Our Ref: BE/98/21/NMA

Non material amendment following the grant of BE/135/18/PL for the adjustment of bell mouth access to the unit 3 plot and associated planting. The new planted bund to north of unit 3 plot within village buffer to provide screening of unit 3 building.

Land At Salt Box West Of Shripney Road Bognor Regis PO22 9NW

Saltbox, Bognor Regis
NMA Planting Plan 2 of 3

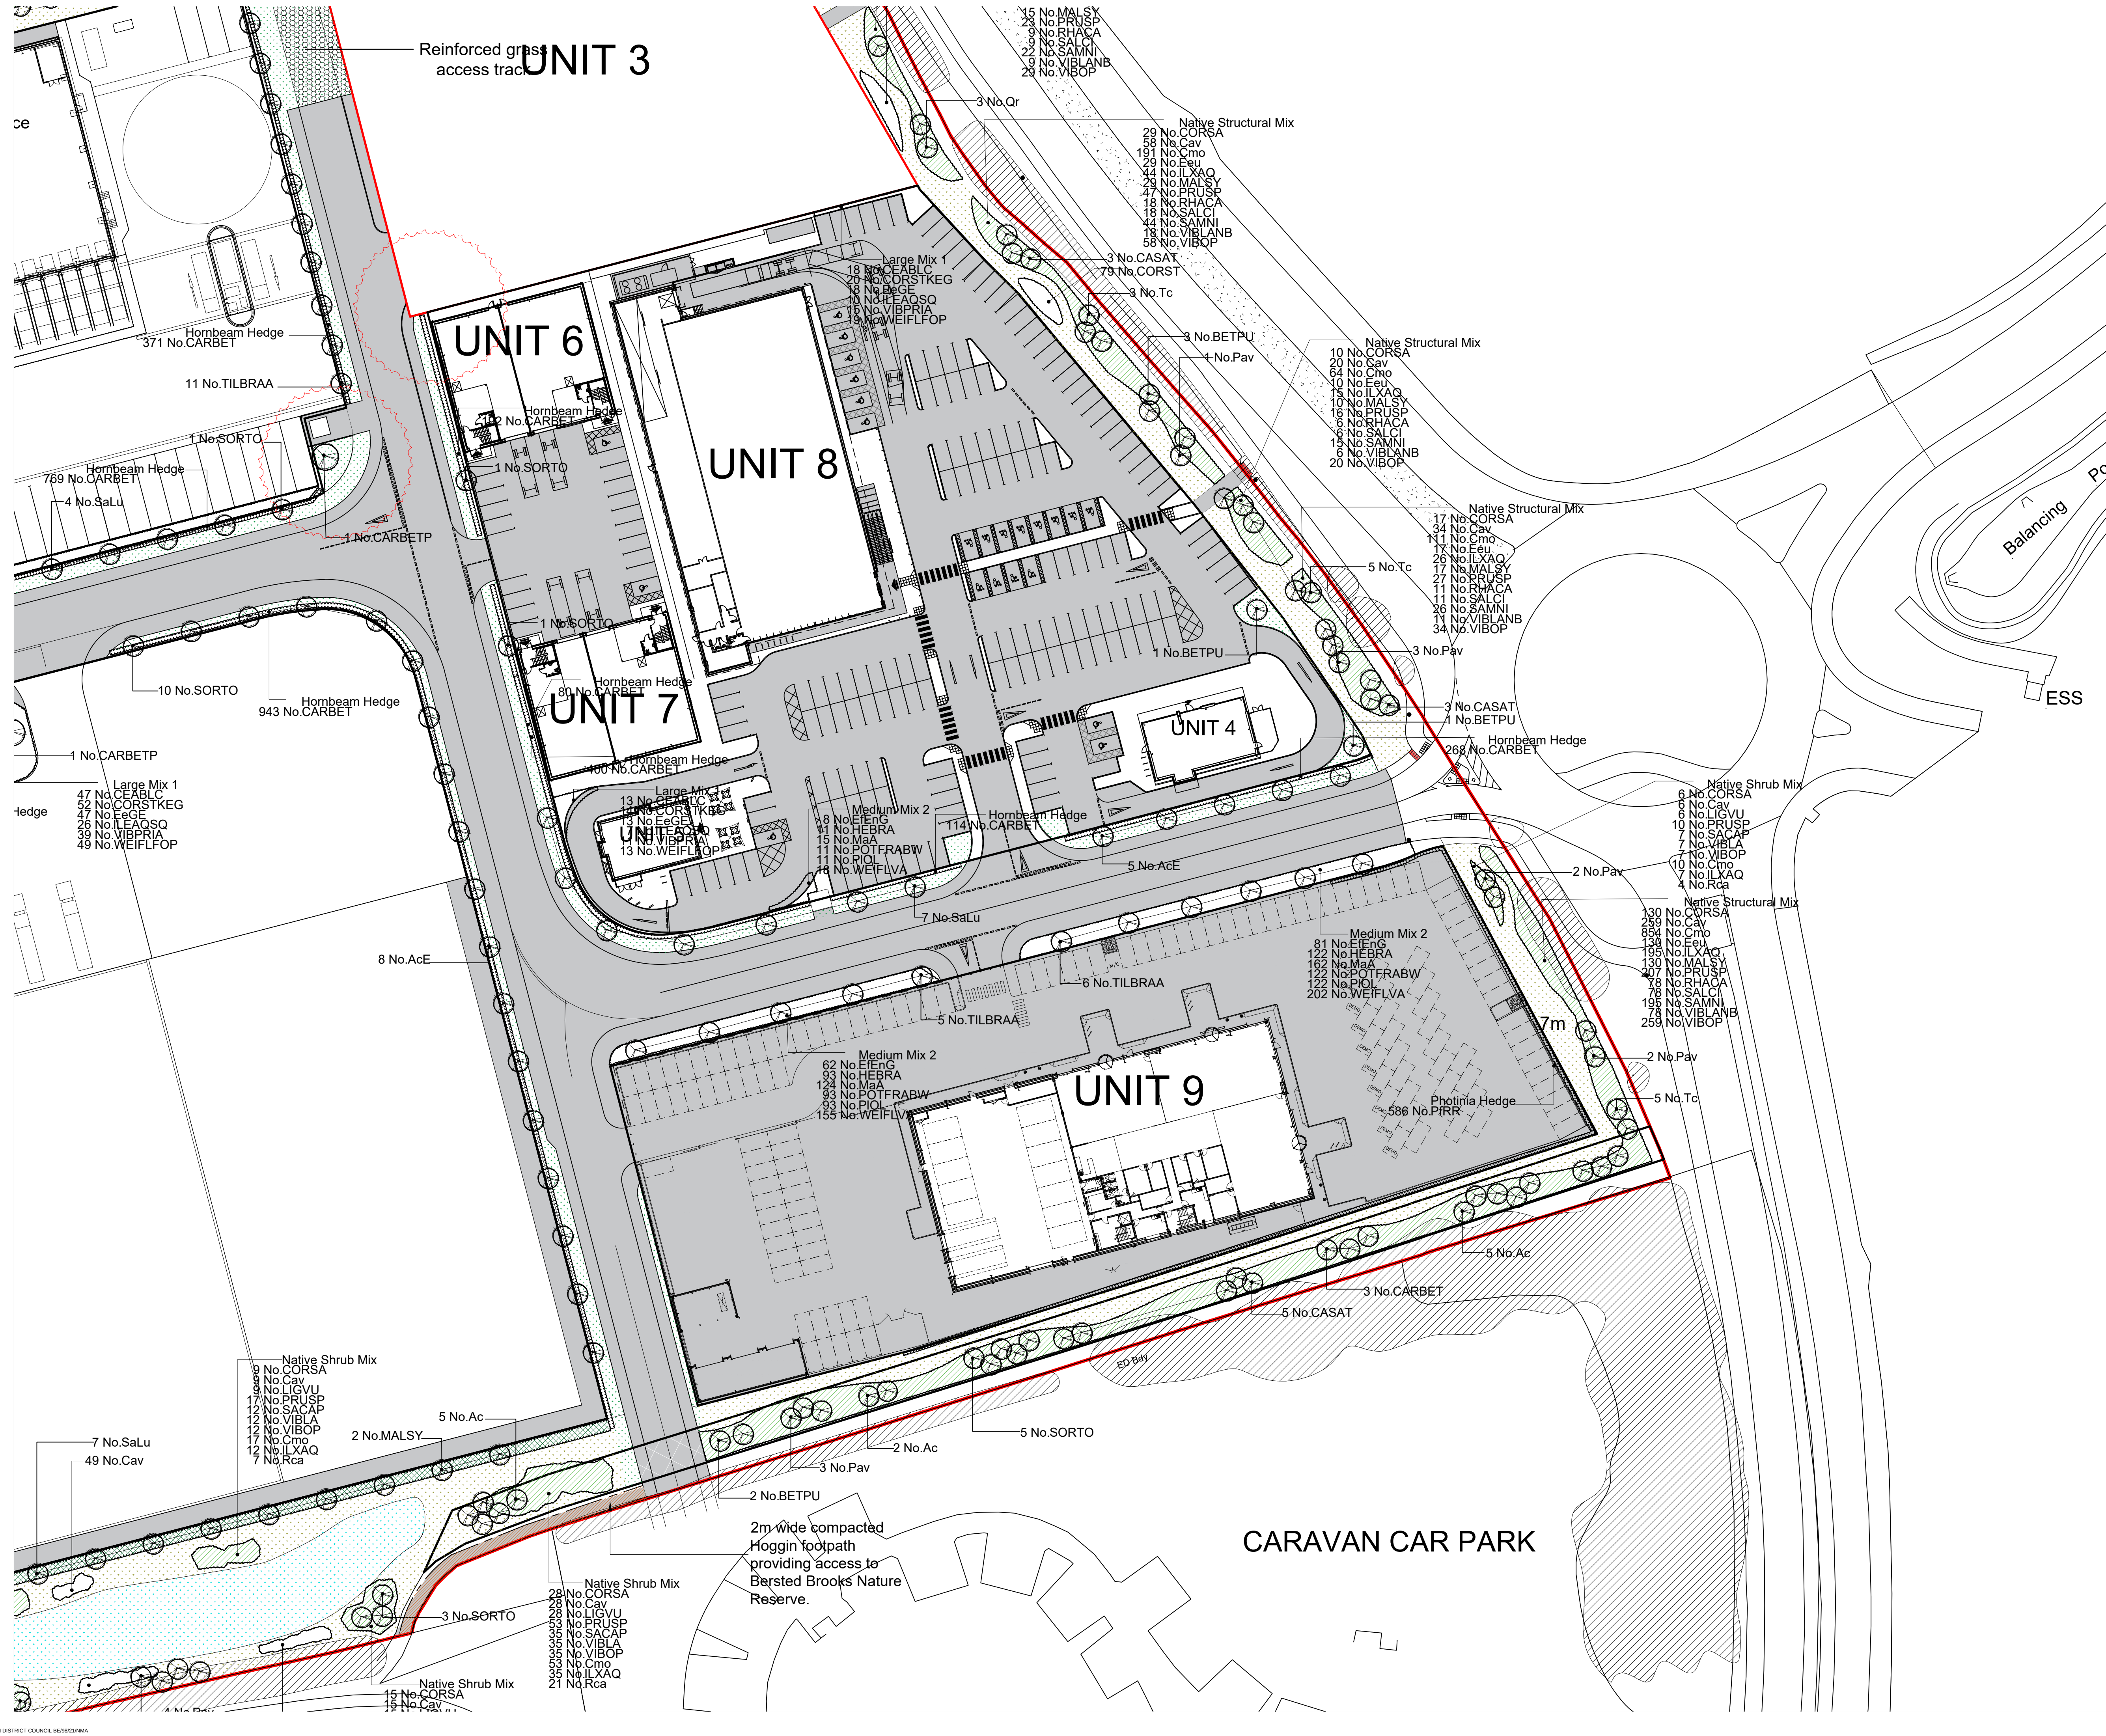
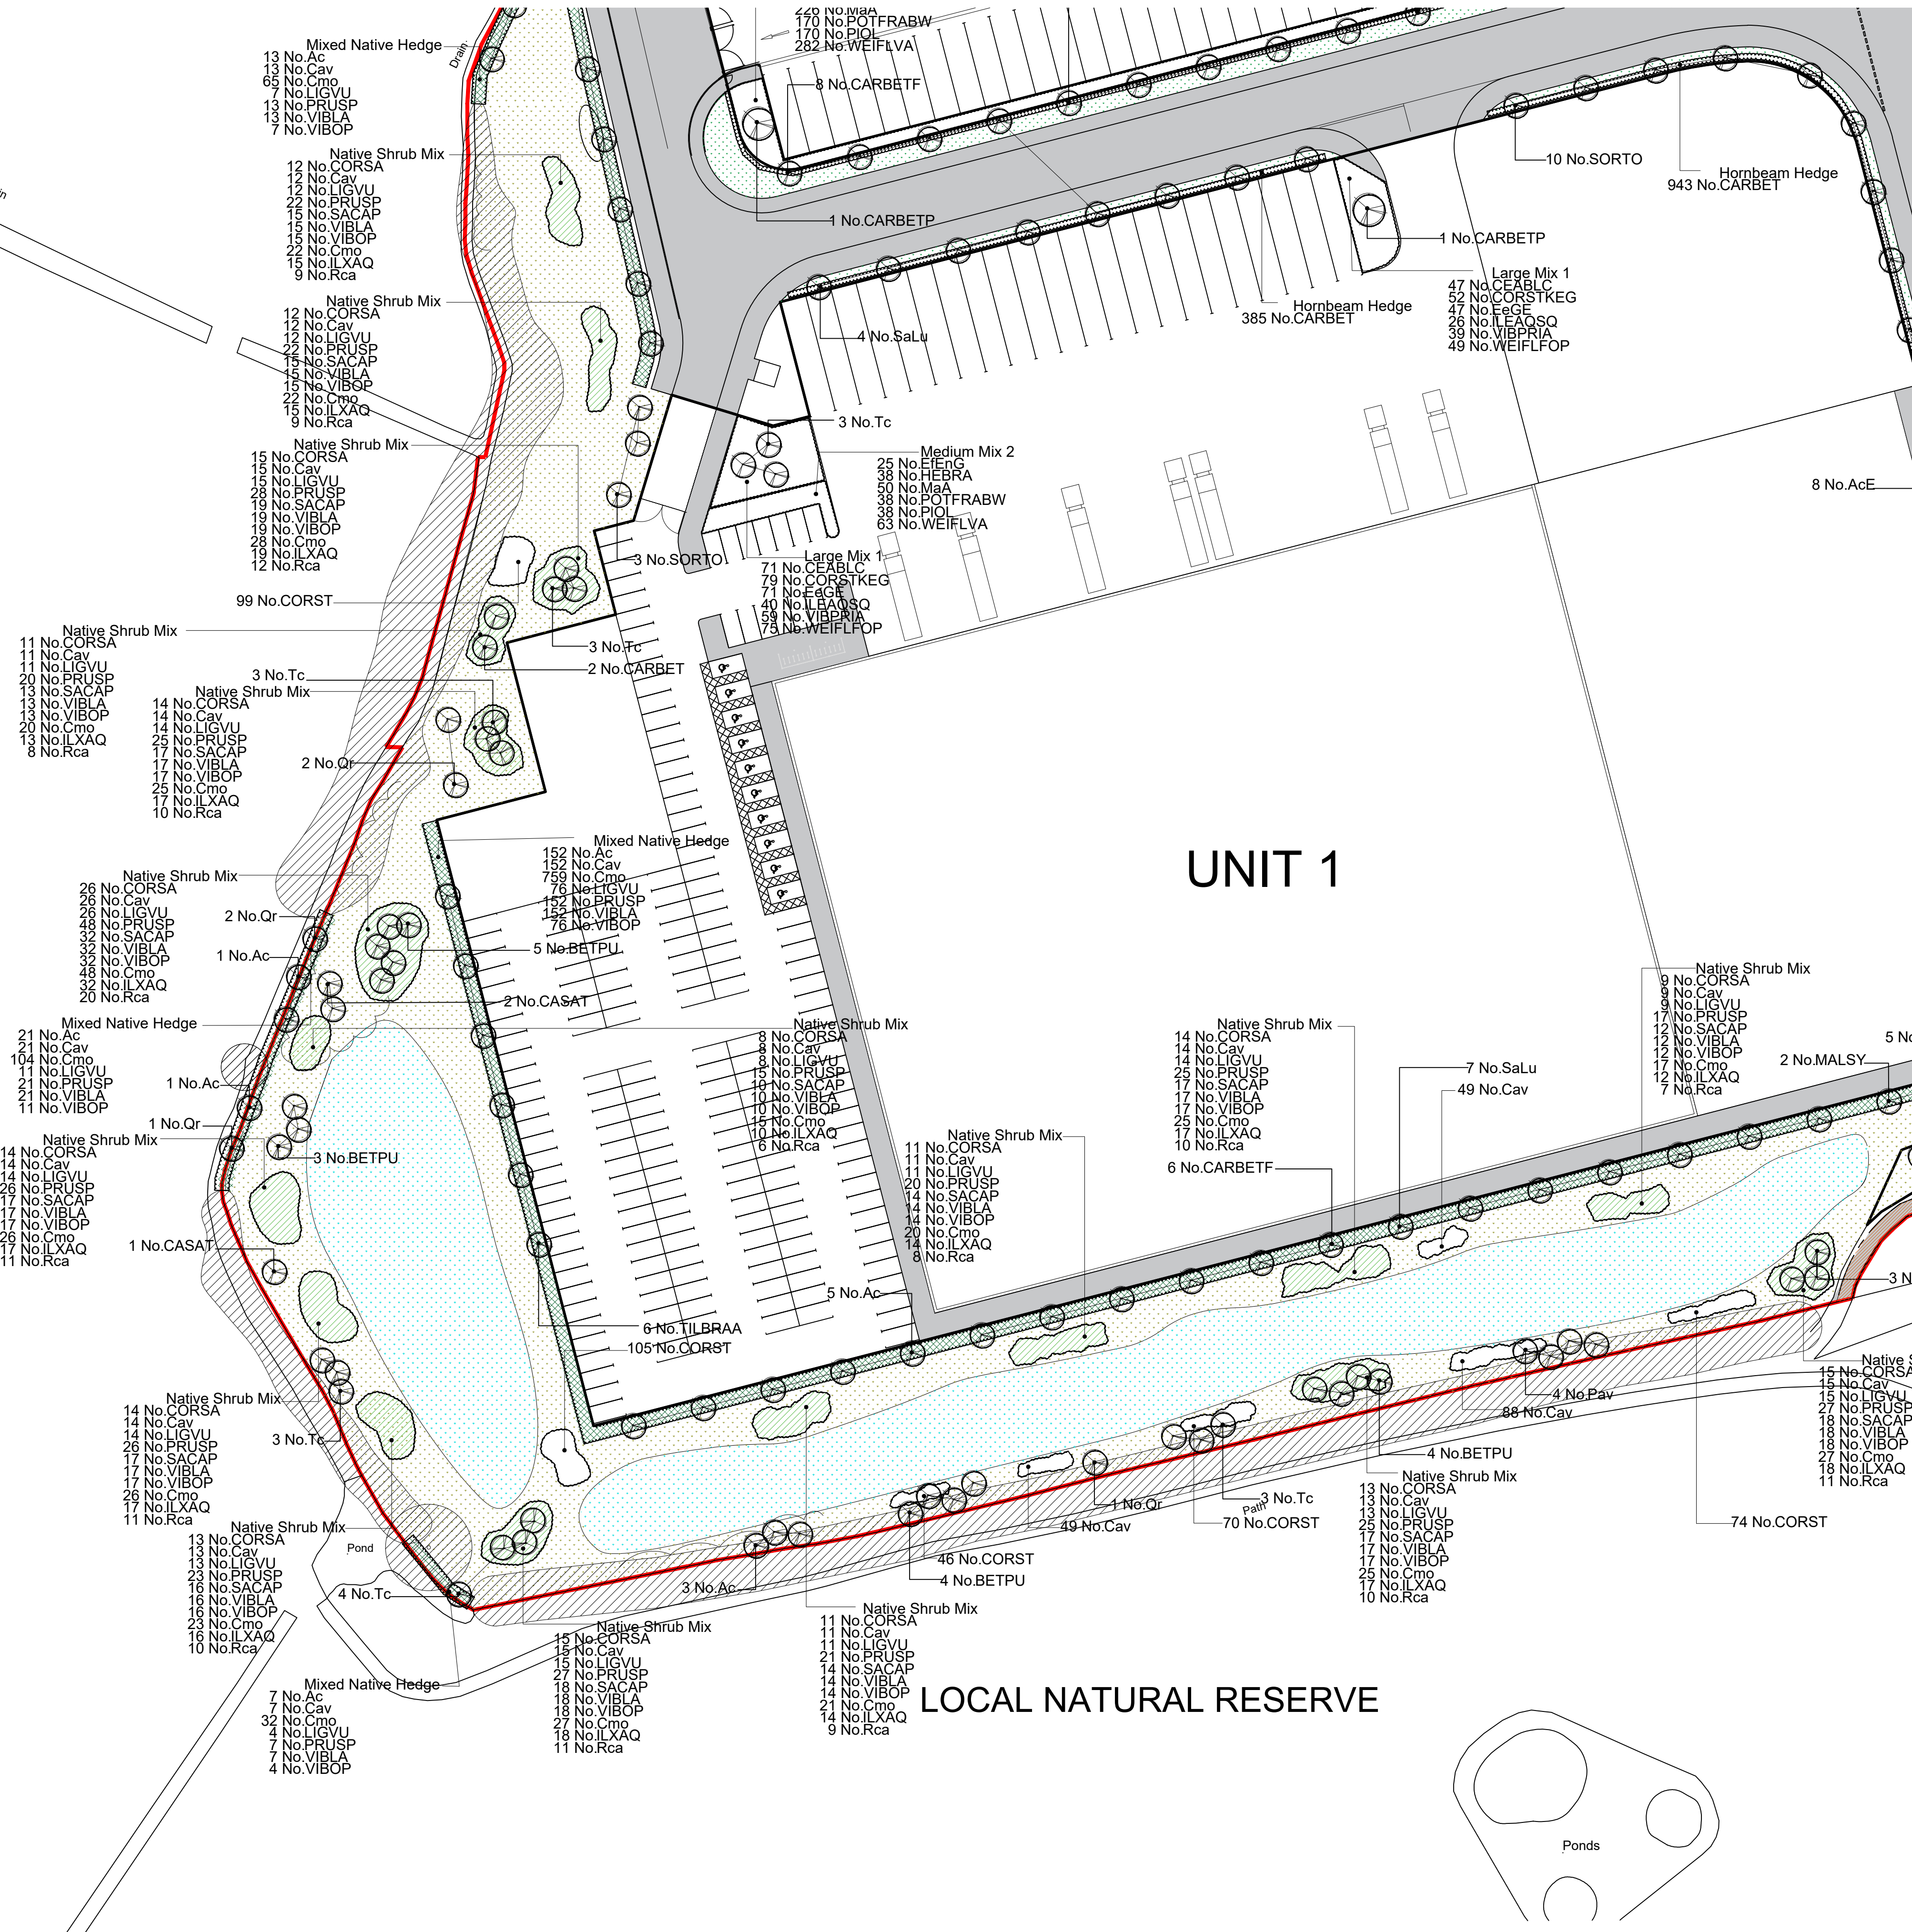
The reason that this proposal has not been accepted as a Non-Material Amendment is because the landscaped bund along the northern side of Unit 3 is not non-material. No details have been submitted of the volume of material that is needed to create the bund or how high it is, or any details of the tree and shrub planting. It is our view that the change is material and it constitutes an amendment that could have a material impact on neighbouring residents and would warrant re-consultation either of neighbours, council departments or statutory bodies. Therefore, it cannot be considered under section 96A of the Town and Country Planning Act 1990.

From the information submitted, I am not prepared to take the proposed landscaped bund along the northern side of Unit 3 as a Non-Material Minor Amendment to planning permission (BE/135/18/PL) at Salt Box.
